SSD 6010 - One Residential Building (Student Accommodation) within Darling Drive Plot

Submission by:

Alan Sauran and Suzanne Aubrun

21 July 2013

SHADOW DIAGRAMS: PERSPECTIVE, SHOWING THE PEAK, WINTER SOLSTICE

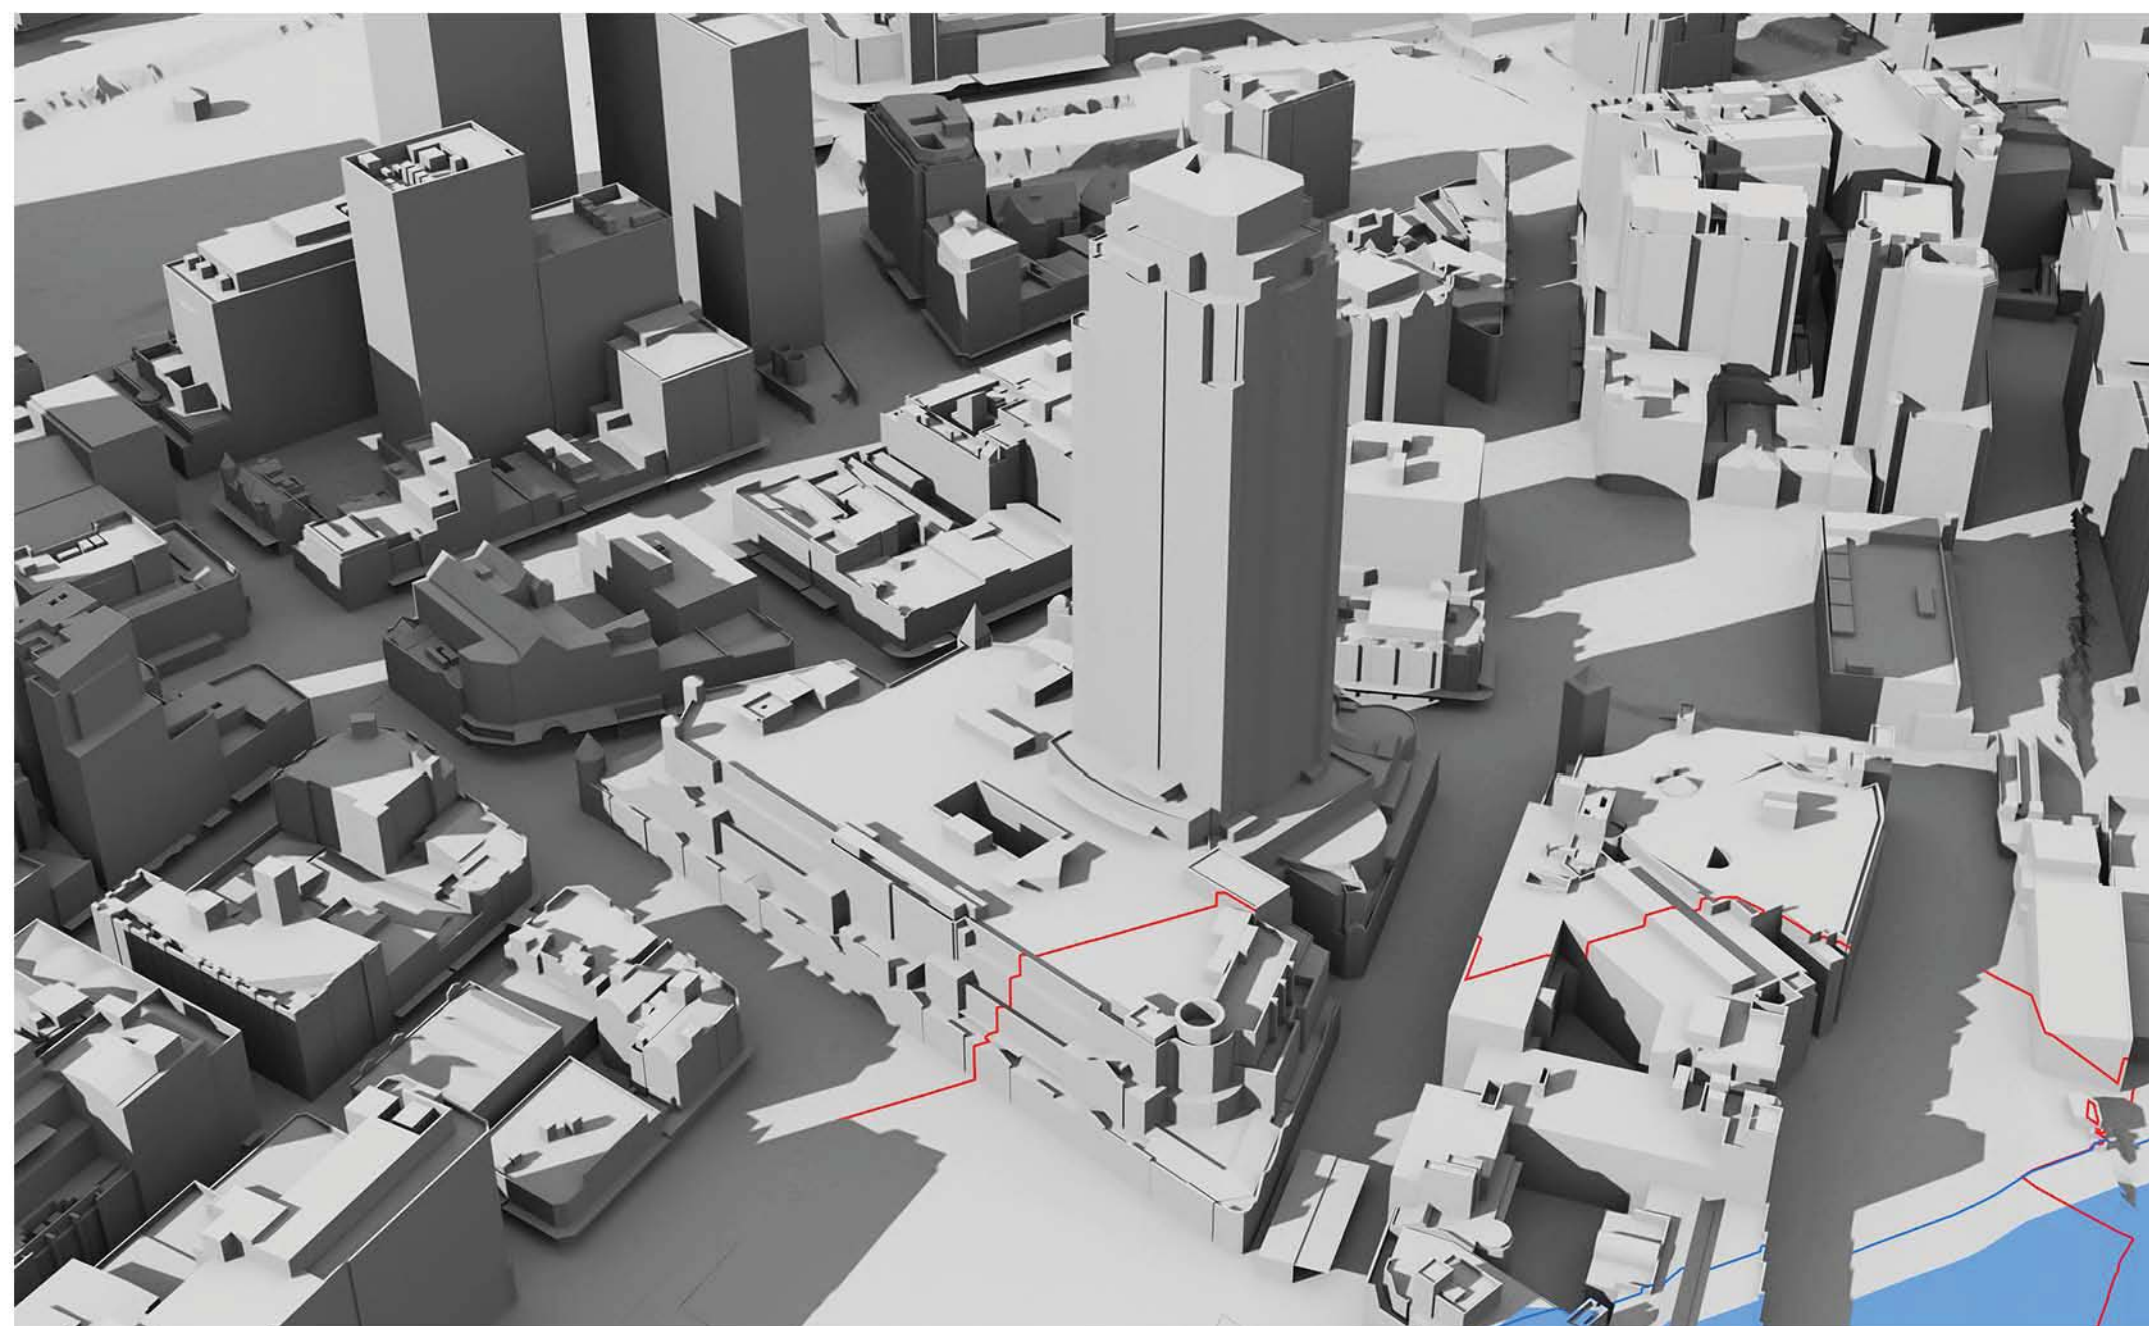
At 9am, 10am and 11am the west façade is totally in shadow due to other parts of The Peak building itself.

At 12pm there is still substantial existing shadowing on the west façade caused by the irregular shape of the west facade.

At 1pm the existing shadowing has been substantially removed, but not totally removed.

It can be concluded that some single aspect apartments on the west façade and some south-west dual aspect corner apartments currently receive less than 2 hours direct sunlight to habitable rooms and 50% of the private open space between 9am and 3pm on 21 June.

By 2pm the existing shadowing has been totally removed, but that is too late to achieve two hours of direct sunlight before 3pm.

At 9am, 10am and 11am the west façade is totally in shadow due to other parts of The Peak building itself.

At 12pm there is still substantial existing shadowing on the west façade caused by the irregular shape of the west facade.

At 1pm the existing shadowing has been substantially, although not entirely, removed. However, overshadowing of lower levels of the west façade by the concept proposal parameter plan shadows for the N,NE and SE plots has already started.

By 2pm the existing shadowing has been totally removed. However, overshadowing of the west façade by the SSDA4 and SSDA5 buildings has appeared and risen further up the west façade than the concept proposal parameter plan shadows for the N,NE and SE plots, which is still present.

At 3pm, the proponent states correctly that 45-45% of the western façade is overshadowed by the SSDA4 and SSDA5 buildings.

It can be concluded that, as a result of combination of the proposed development with existing shadowing of the west façade, some single aspect apartments on the west façade and the south-west dual aspect corner apartments which currently receive less than 2 hours direct sunlight to habitable rooms and 50% of the private open space between 9am and 3pm on 21 June will suffer additional overshadowing. It is beyond our skills to count the number of such apartments. We note that the proponent has made no attempt to do so.
